**Ivanhoe Estate Redevelopment – Concept (SSD 8707)
EPA comment on Response to Submissions**

I am writing to you in reply to the invitation to the Environment Protection Authority (EPA) to provide comment on the Response to Submissions (RtS) for the Ivanhoe Estate Redevelopment – Concept.

## Appendix 2- Unattended Noise Data of Location 2

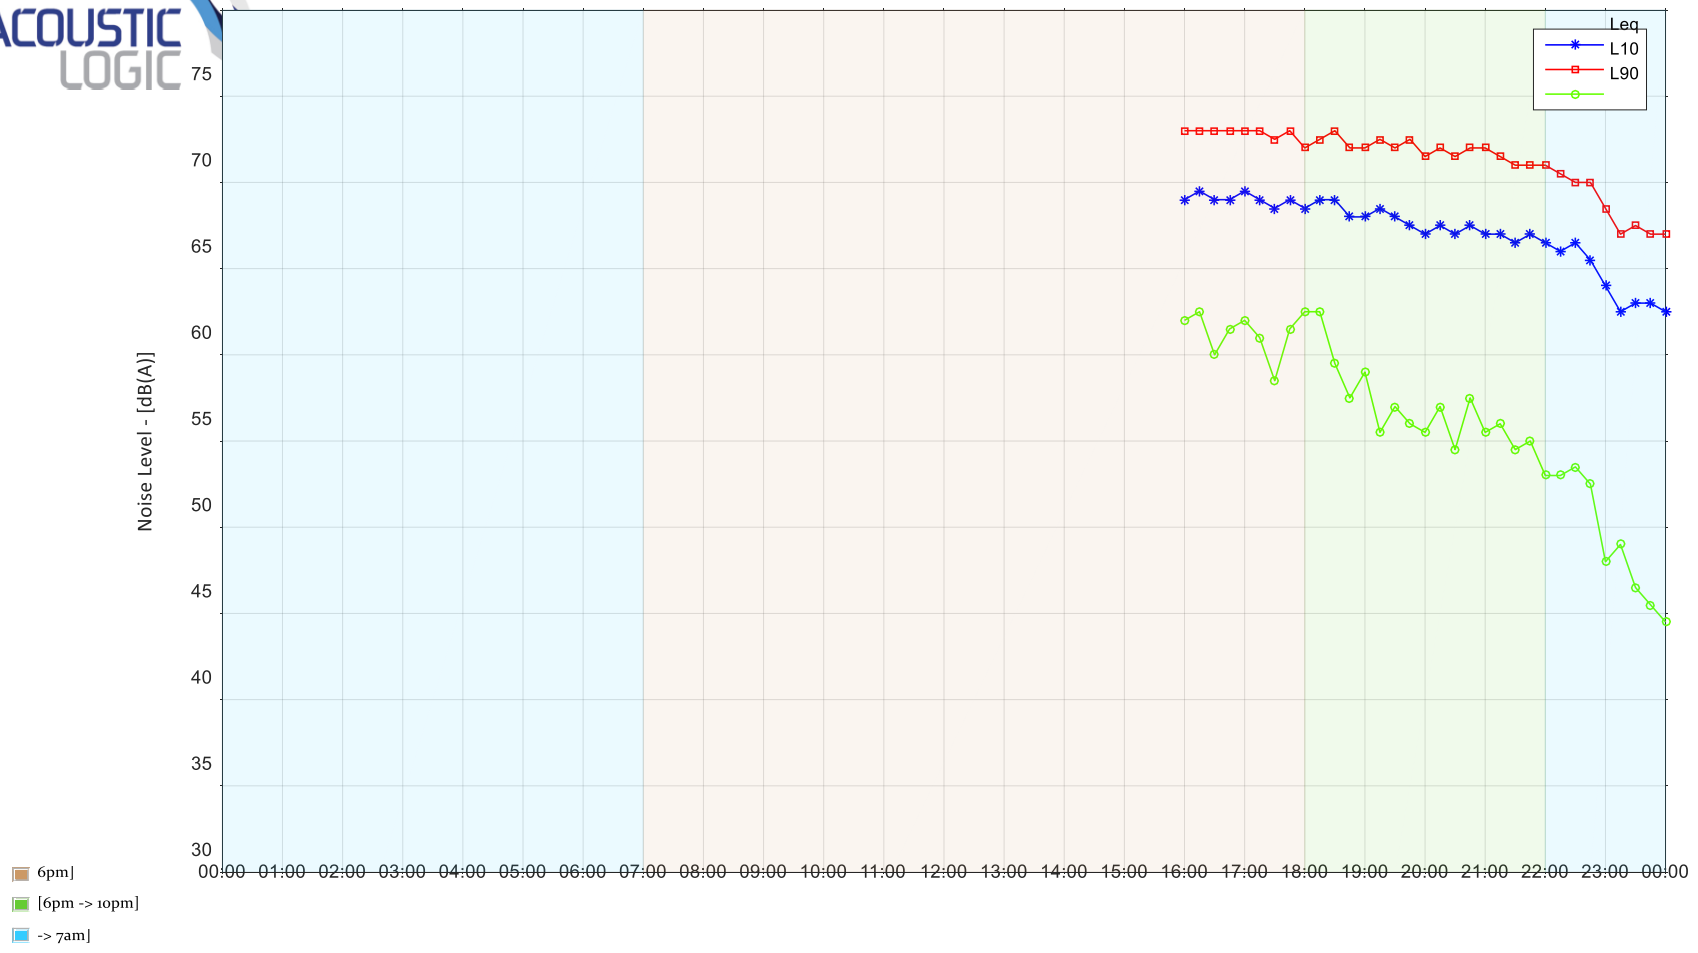
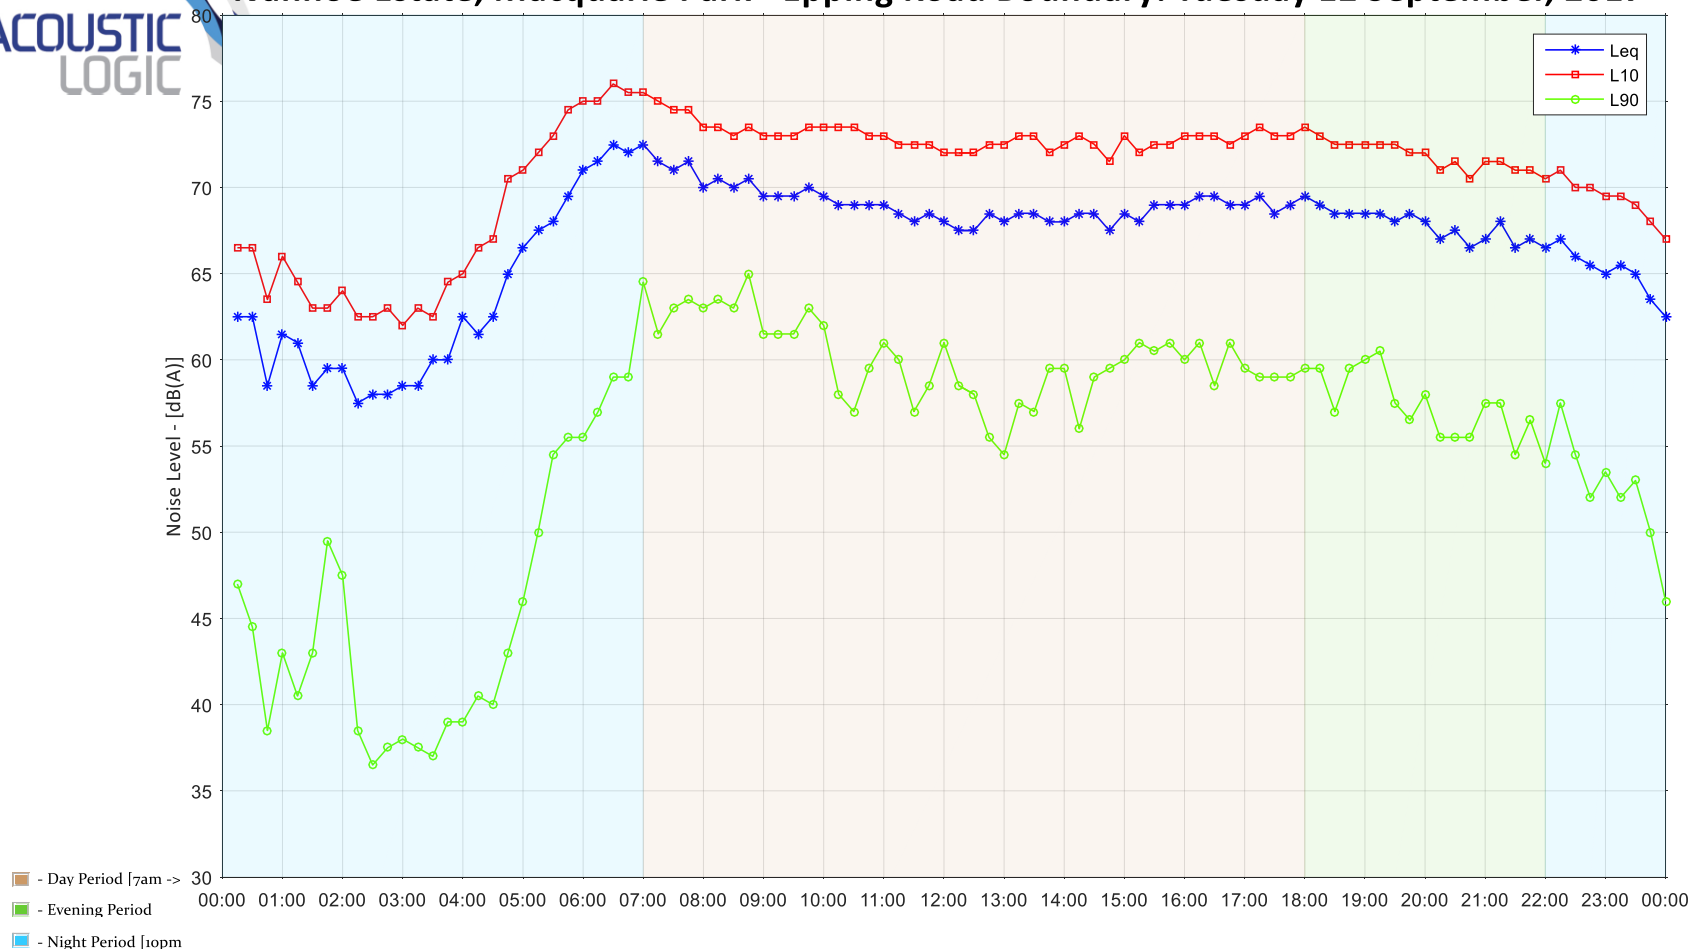
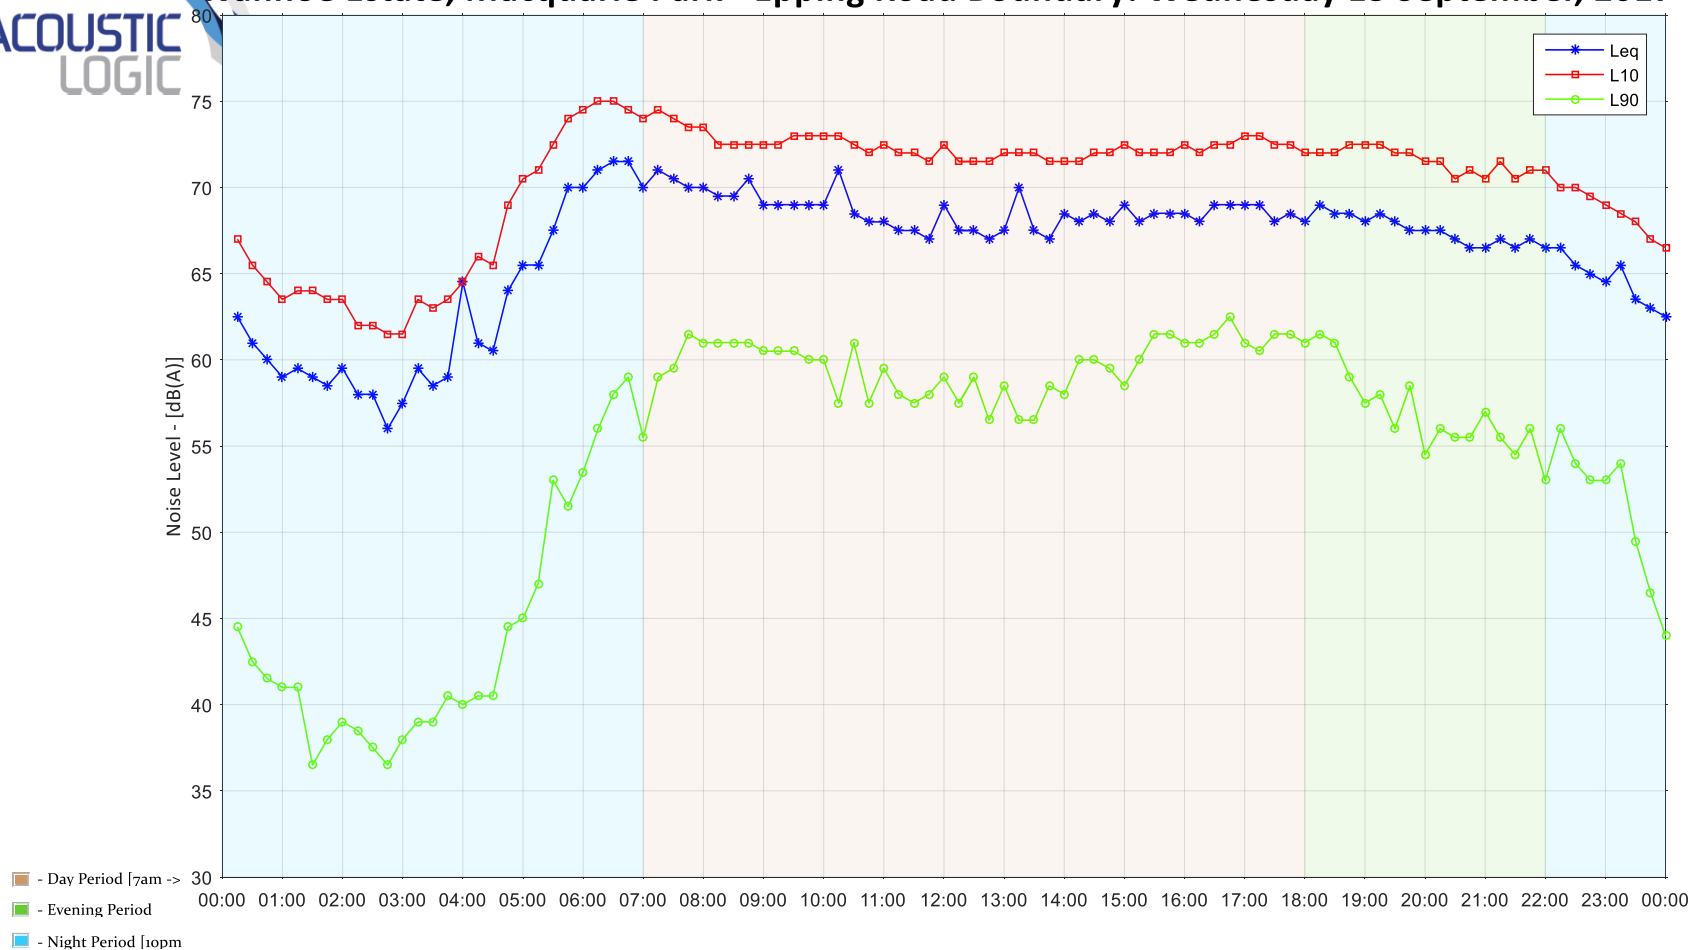
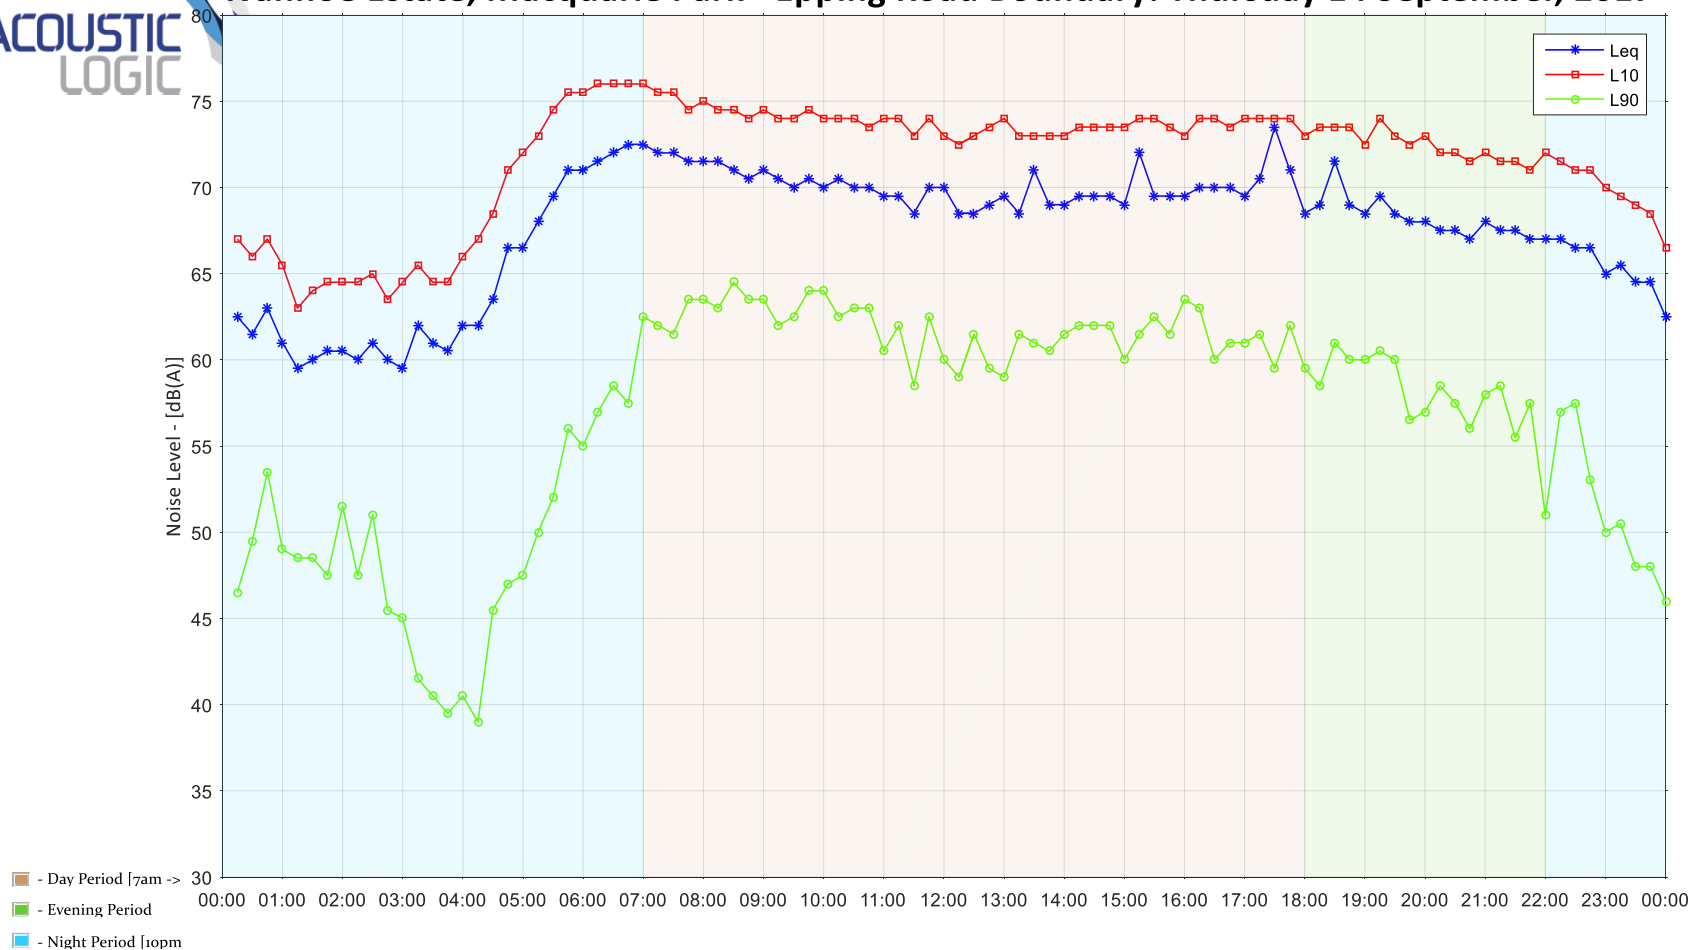
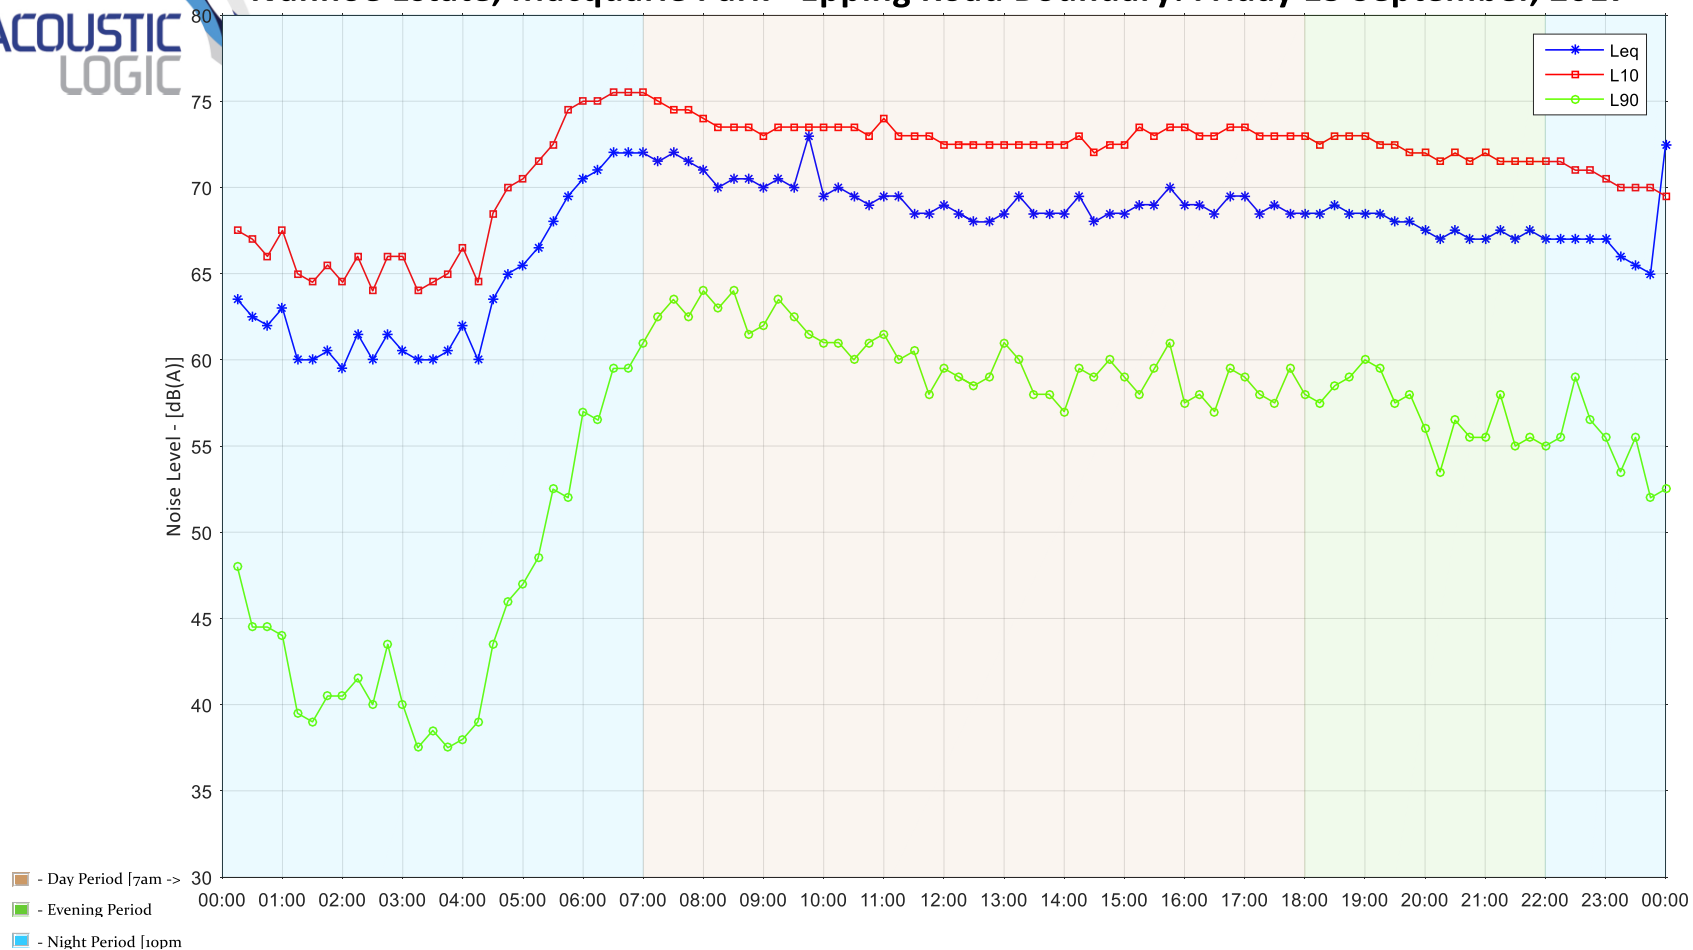
- Further to this, some of the measurement data presented in Table 1 of the Acoustic Logic letter has been removed due to adverse weather. However, this has been done inconsistently. For example, measurements at Location 2 and Location 5 were carried out over the same time period in September 2017, but data from different periods have been removed. Inconsistencies are also apparent with Locations 4 and 6, undertaken over the same period in October 2017. There are six periods removed for Location 4 which were not removed for Location 6, without explanation. It appears that this was due to adverse weather data, and therefore it is not clear why this data was removed at one location and not the other. No explanation was provided in the information submitted.

- Wind and rain data have been included on the monitoring graphs in Appendices 1 to 6 of the revised RtS noise report, however the location and source of the data has not been included.
